OXFORDSHIRE COUNTY COUNCIL'S RESPONSE TO CONSULTATION ON THE FOLLOWING DEVELOPMENT PROPOSAL

Application no: 22/01632/REM

Proposal: Reserved matters application to 19/01740/HYBRID - layout, scale, appearance and landscaping details for Phase 2 of the employment development (11,309sqm GIA) with associated landscaping and infrastructure works

Location: Land Adj To Promised Land Farm, Wendlebury Road, Chesterton

Drawing Title:
CYCLE SHELTER DETAILS

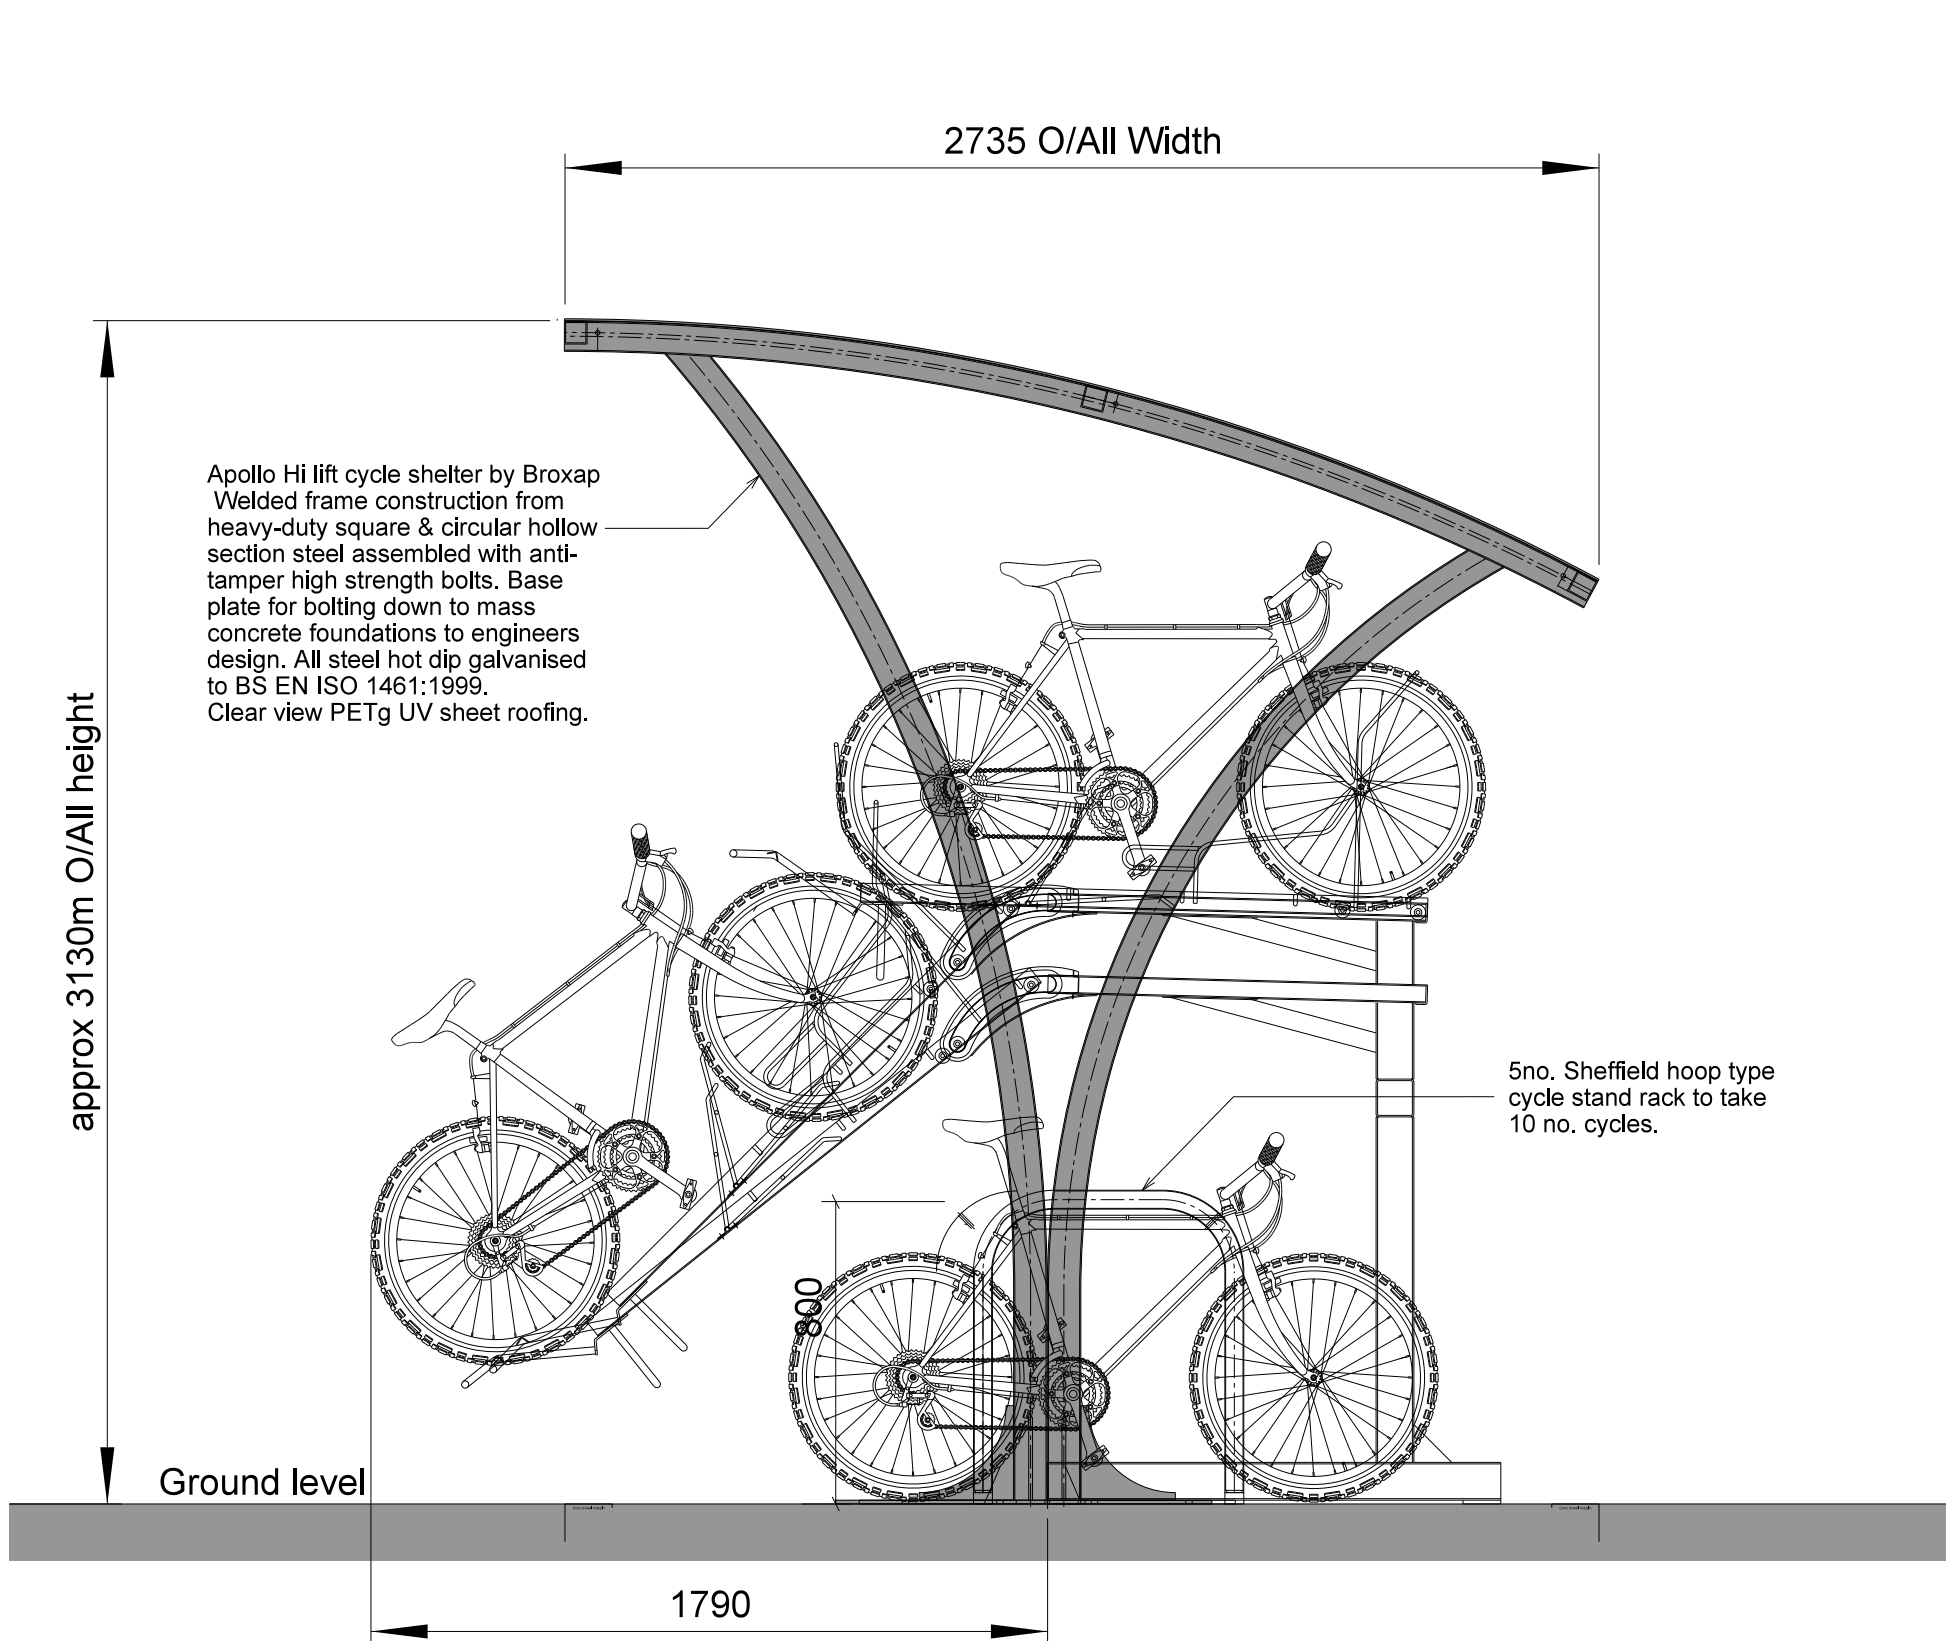
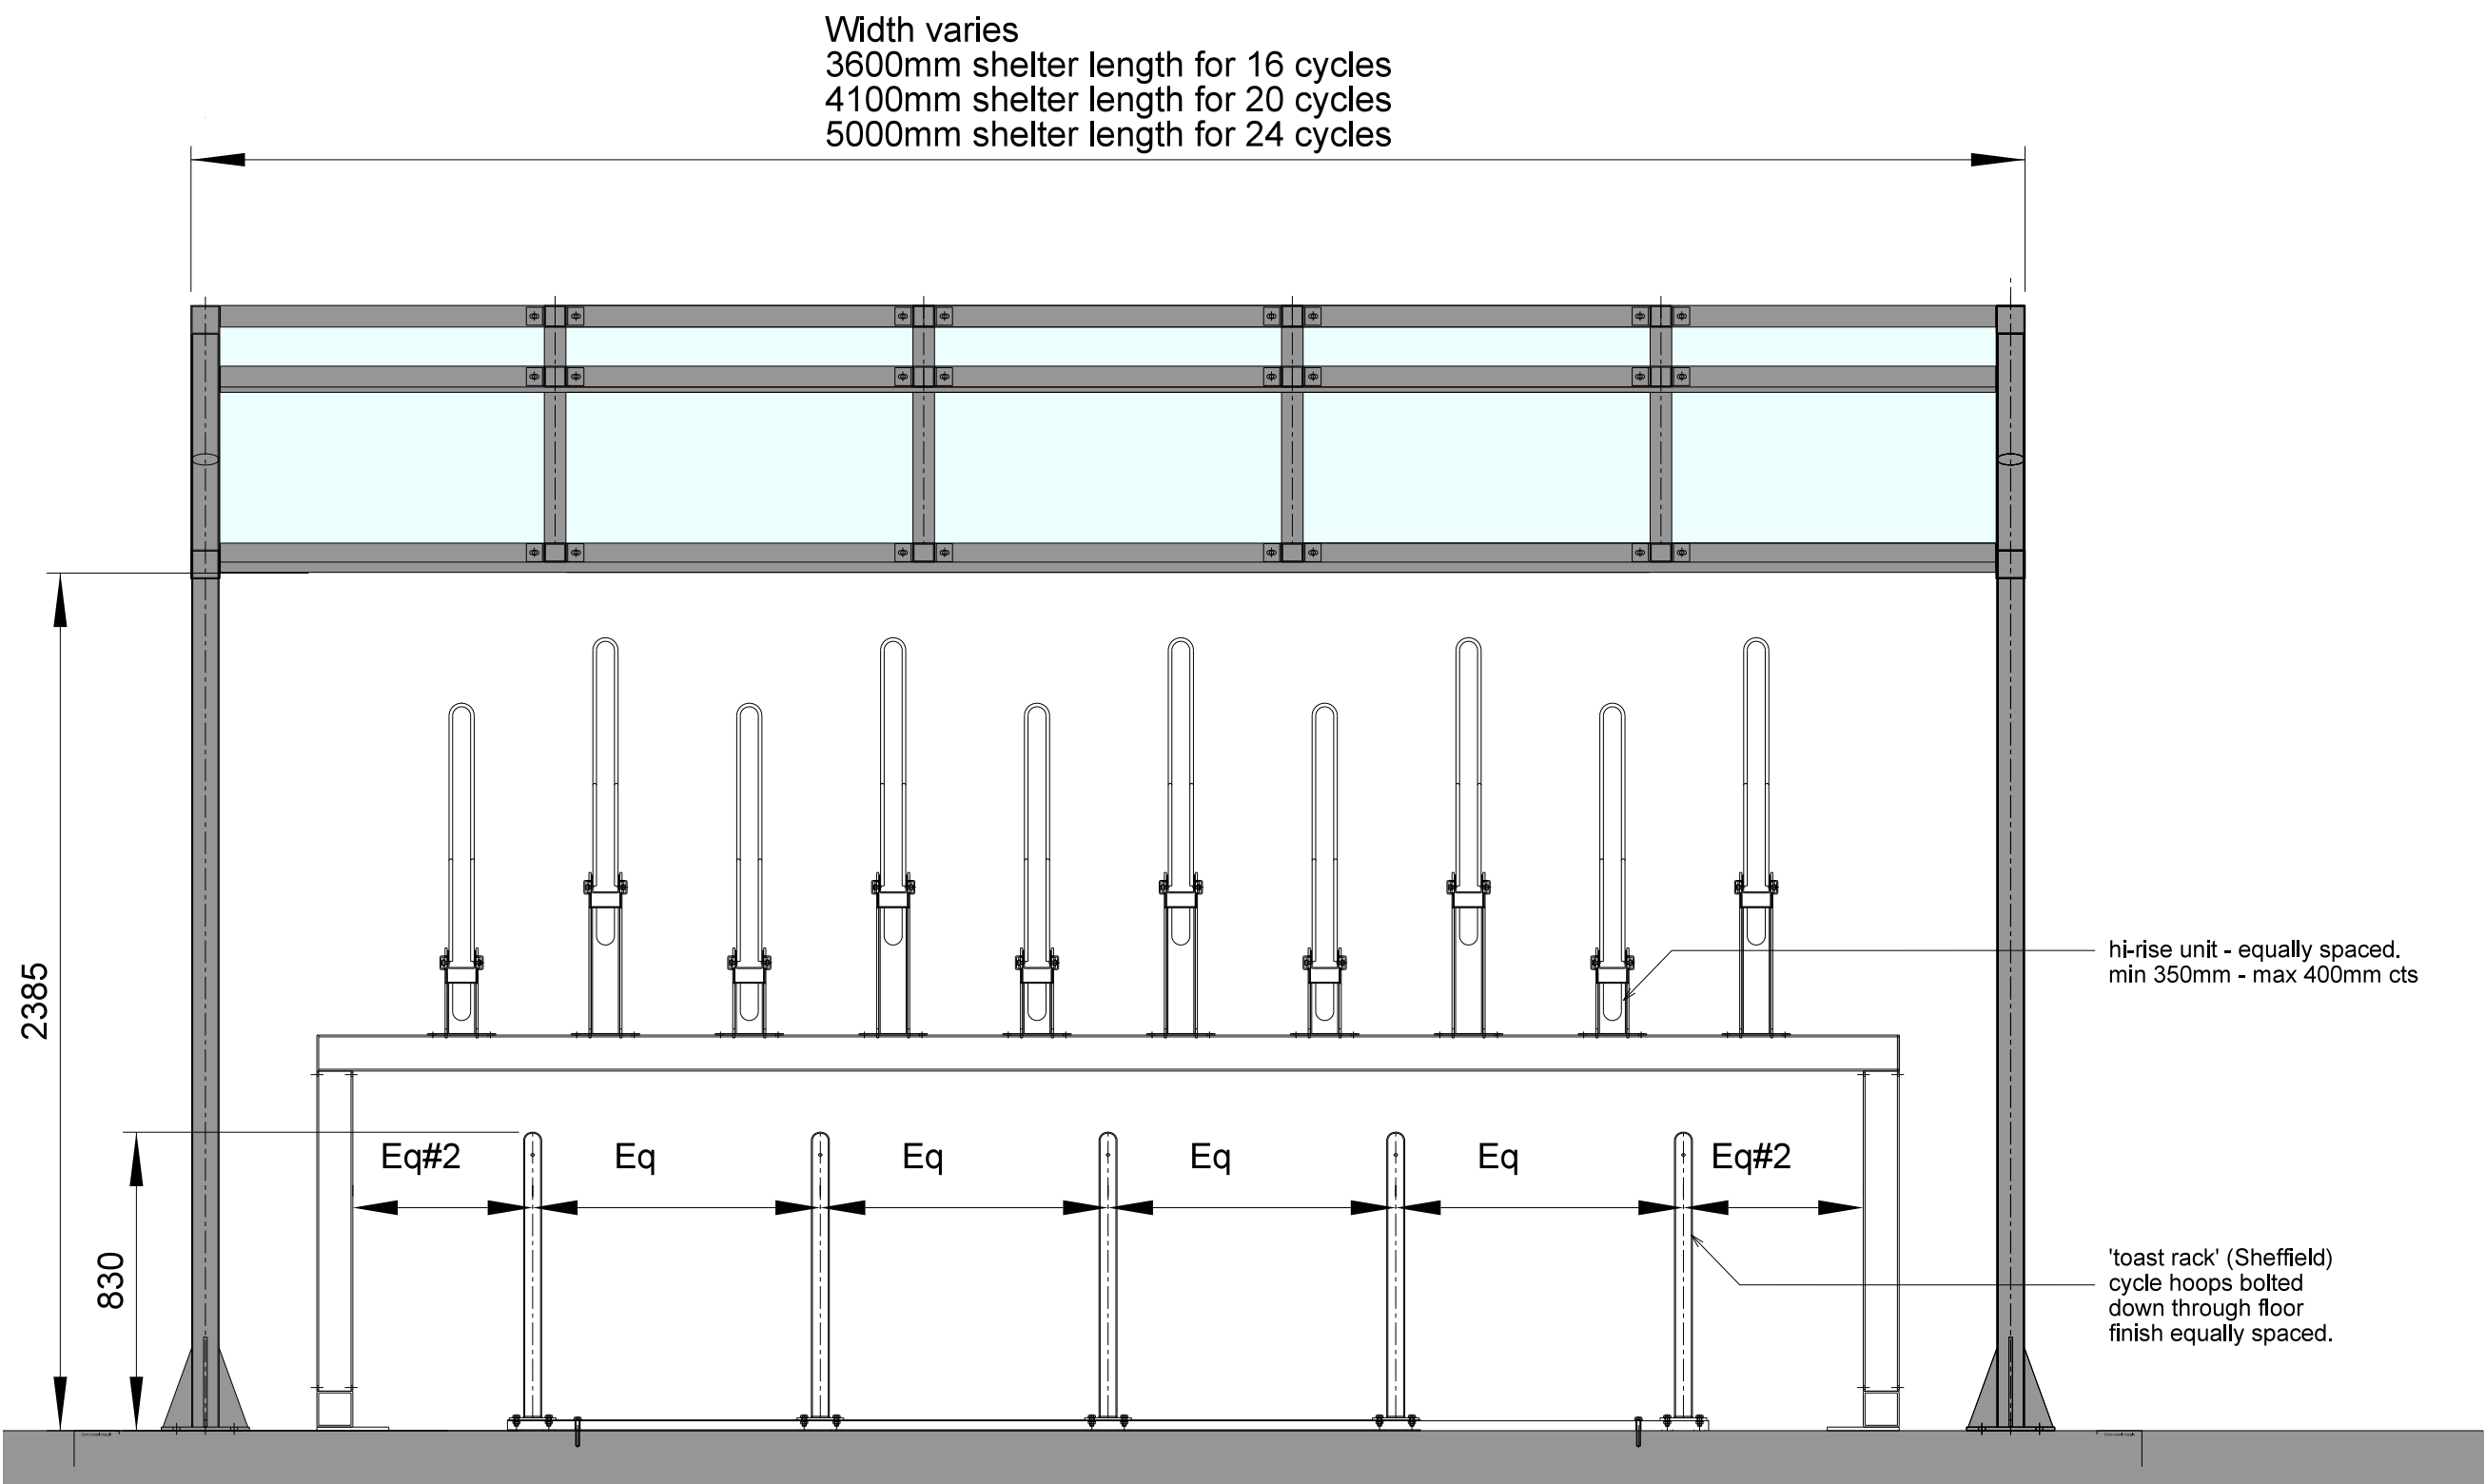
Car and cycle parking - The proposed provision has been reviewed and found to be in acceptable in accordance with the standards.
